**SUBJECT: Comment Response Letter – Bent Grass Residential Filing No. 2 (SF-19-014)**

Please see the following responses in ***bold and italics*** for the 1<sup>st</sup> review of Bent Grass Residential Filing No. 2.

**TYPE 4 OBJECT MARKER**

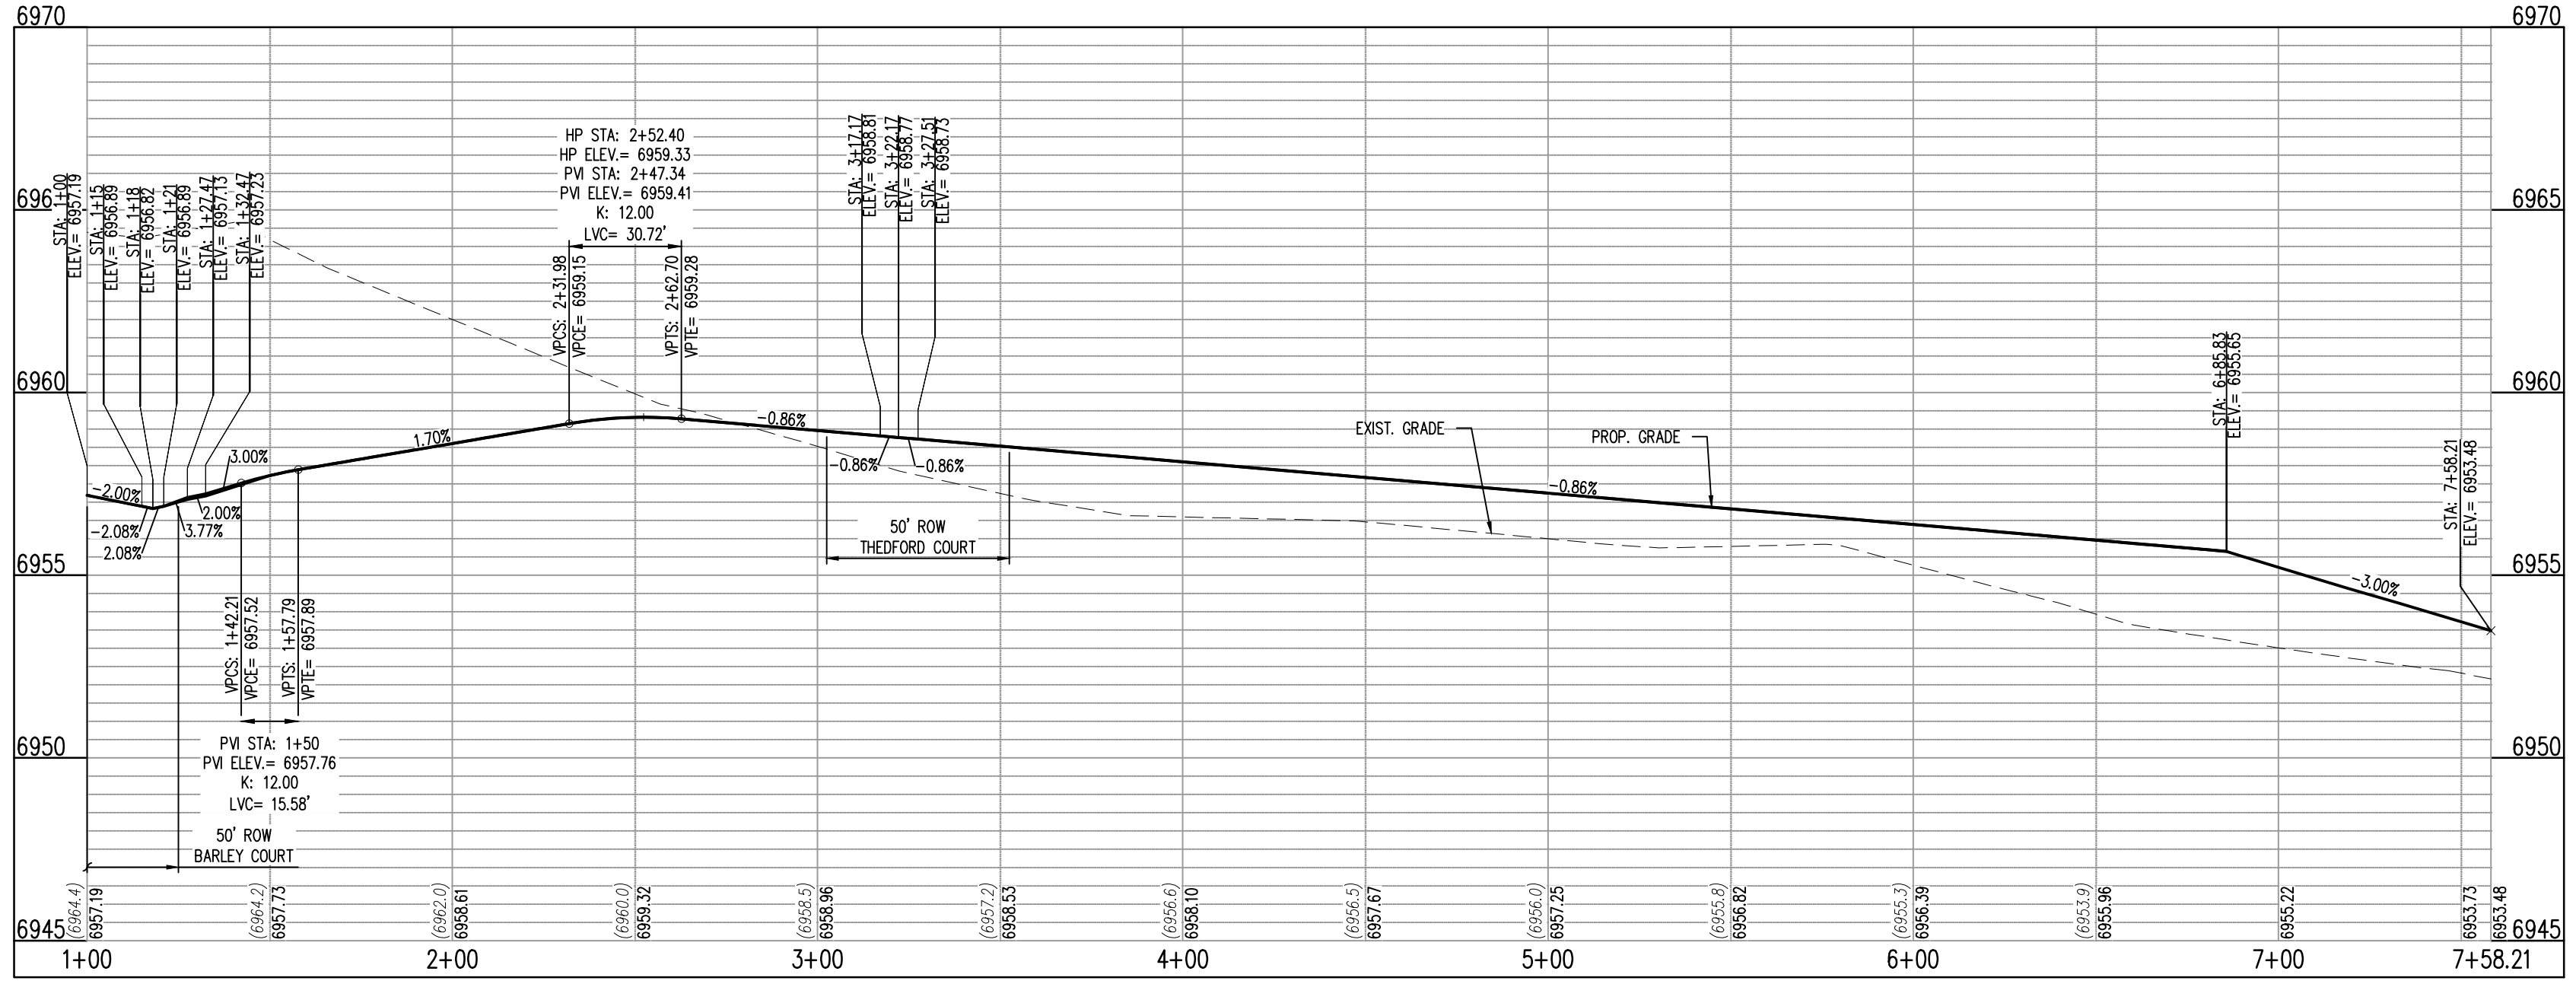
***Response: Revised as requested.***
4. Assess the need for signage at the entrances and ends of the cul-de-sacs (W14-1/W14-2 and Type 4 object markers?).

***Response: Revised as requested.***
5. Show and label all maintenance access roads and the trail on the plans.  
***Response: Revised as requested.***
6. Geotechnical issues:

CULVERT & WINGWALL PLAN: STA. 1+00.00 - 6+75.00  
SCALE: 1"=40'

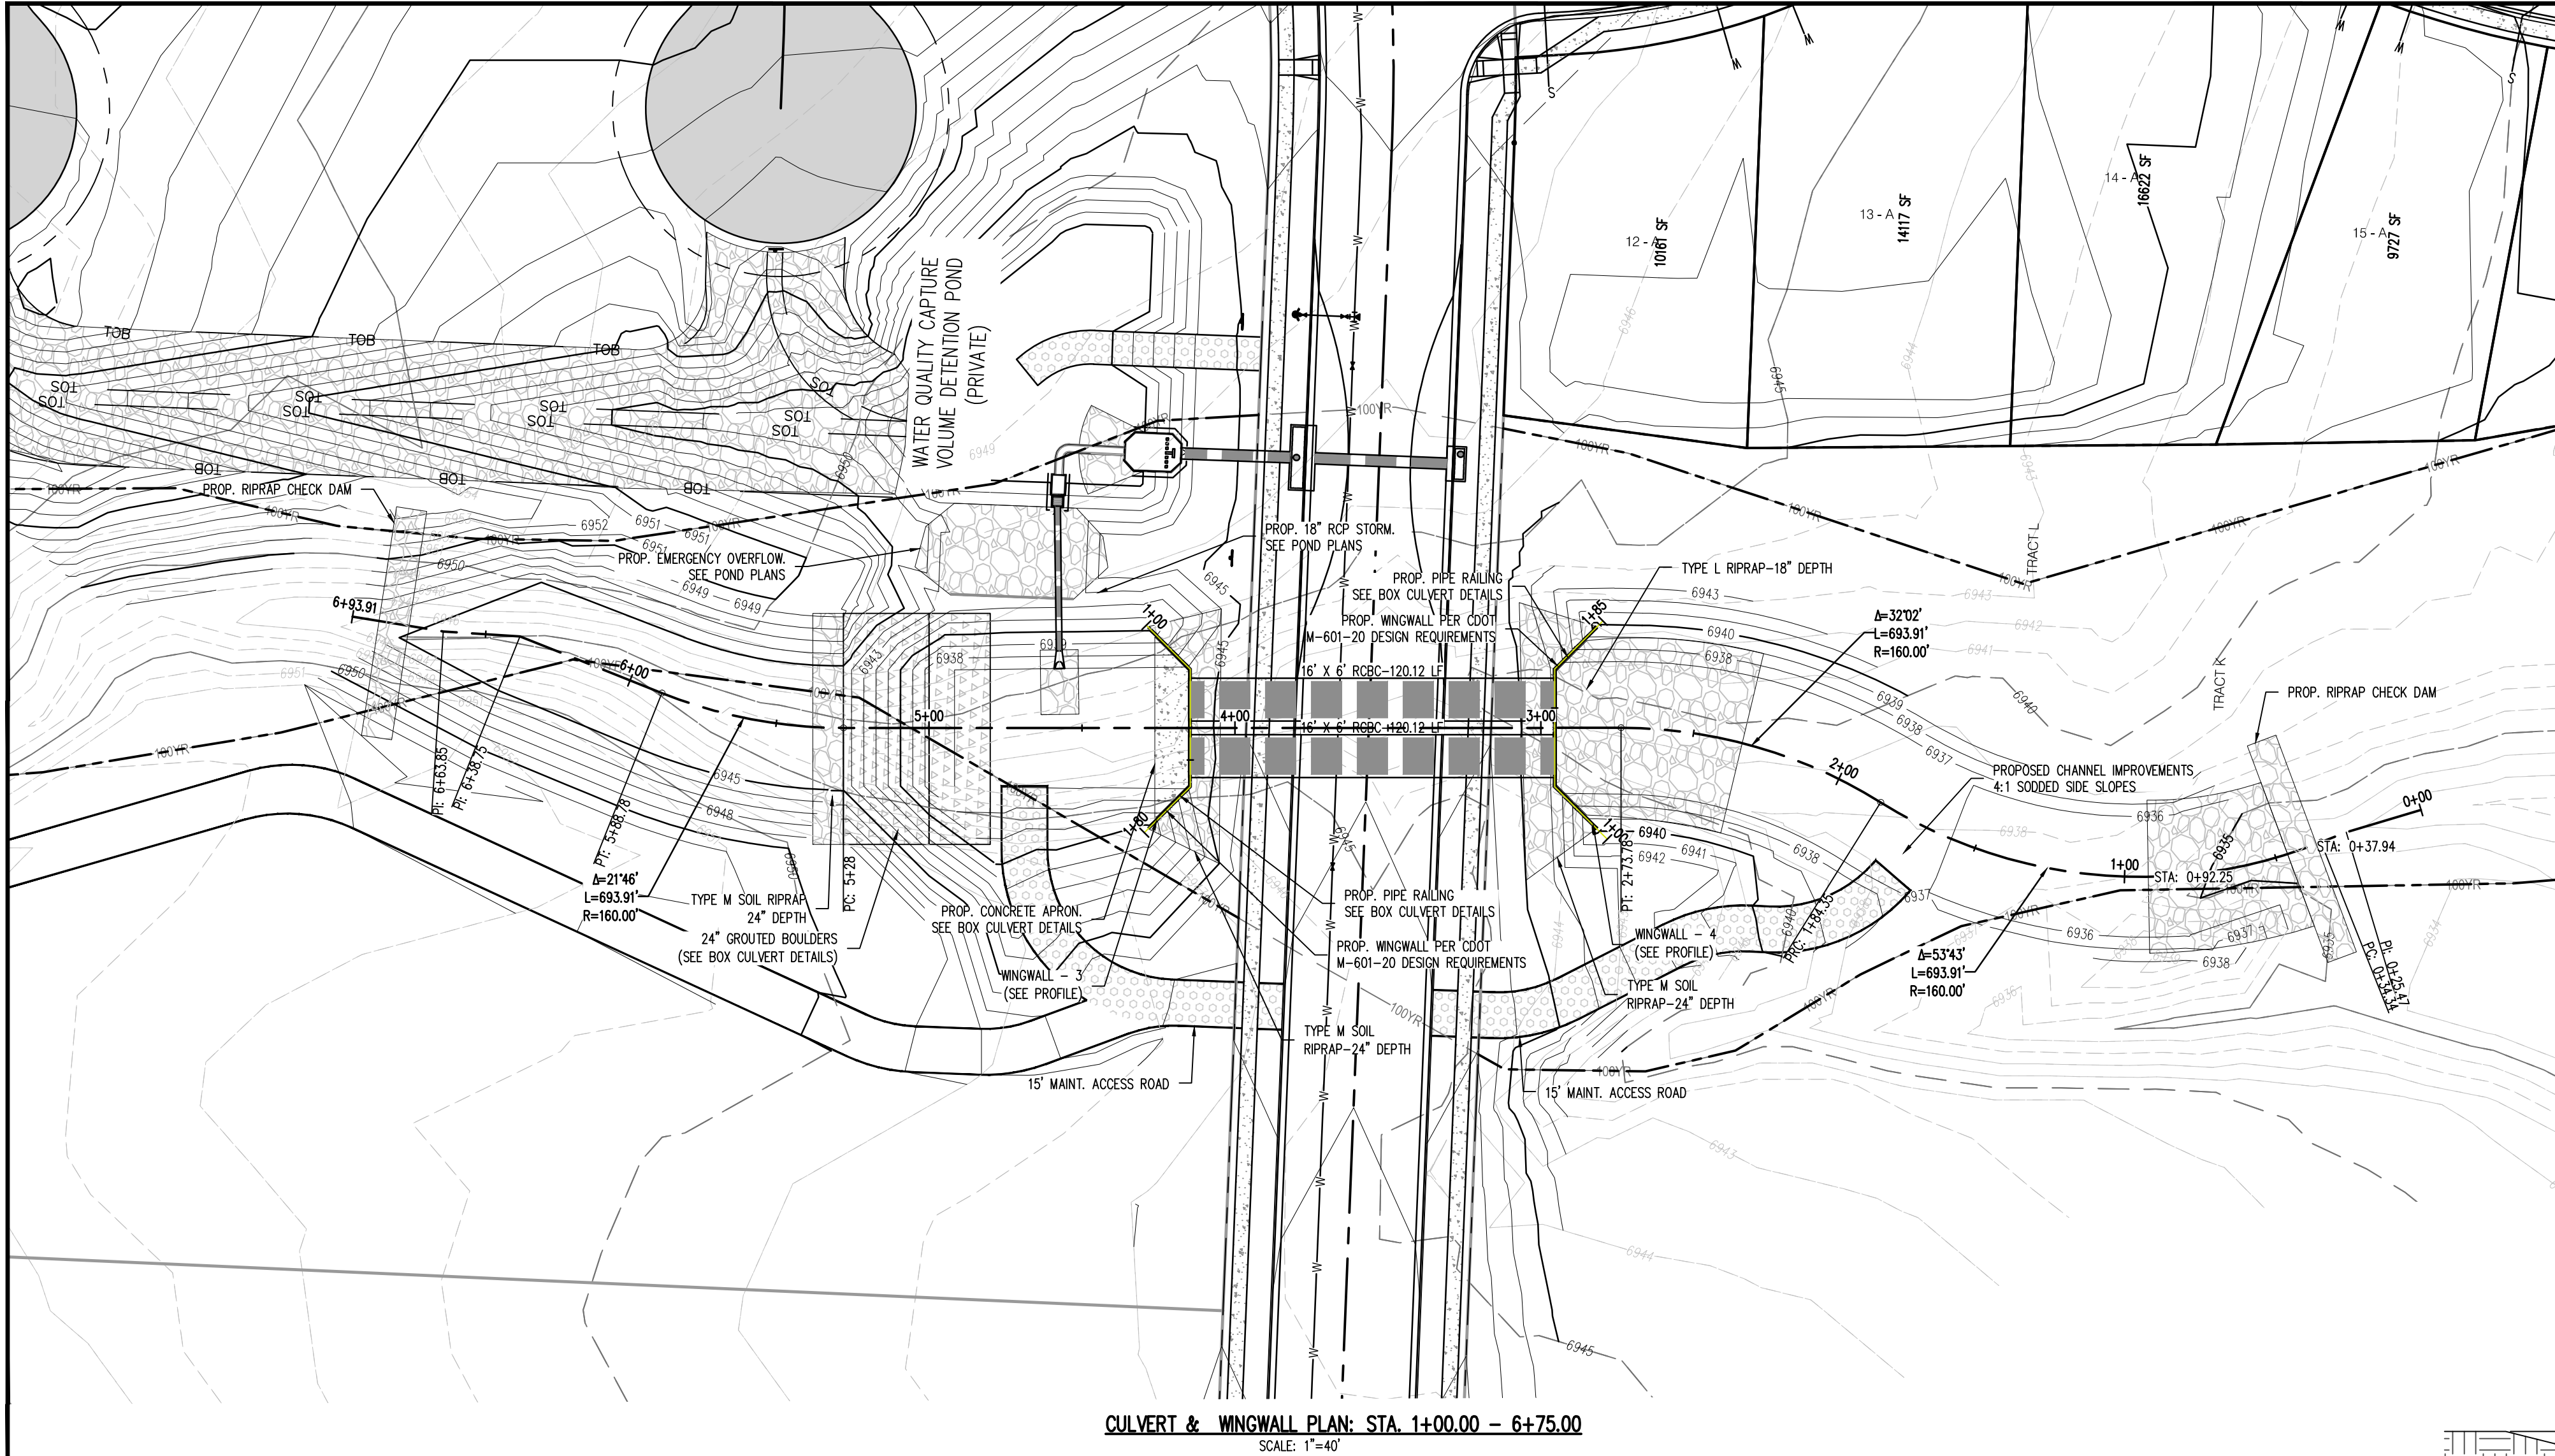
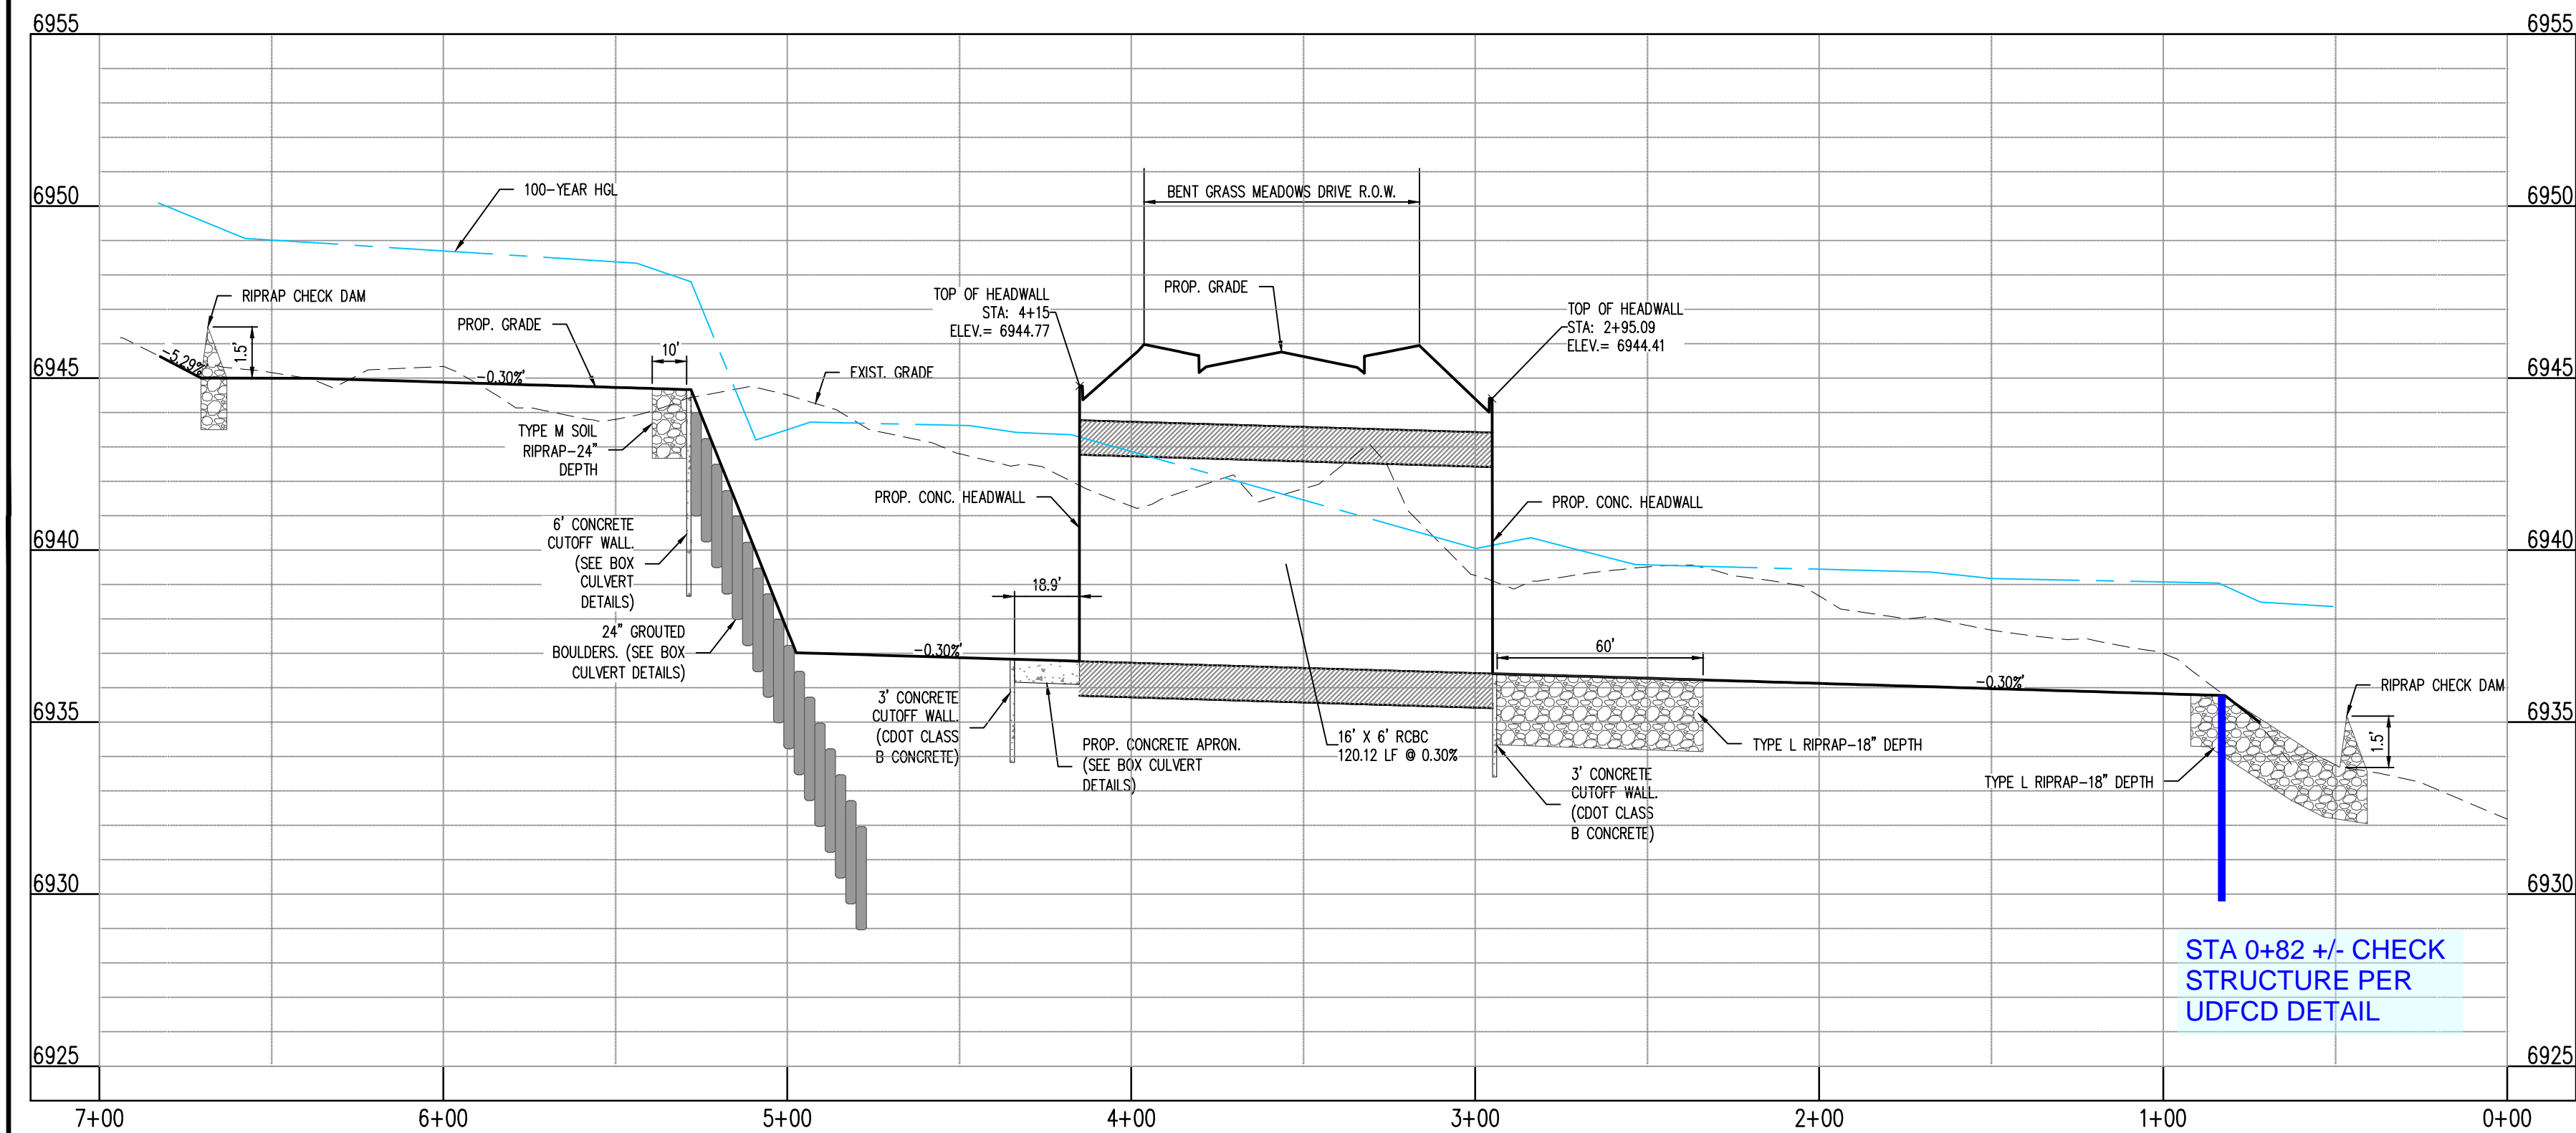
- b. Provide maintenance access to the channel and box culvert.

- d. Verify culvert outlet protection design. It appears that a low tailwater basin/plunge pool may be necessary (DCM10.8.3/UDFCD 9.3.2.2).  
***Response: Revised as requested. See revised FDR.***

***Response: Revised as requested. See revised FDR.***
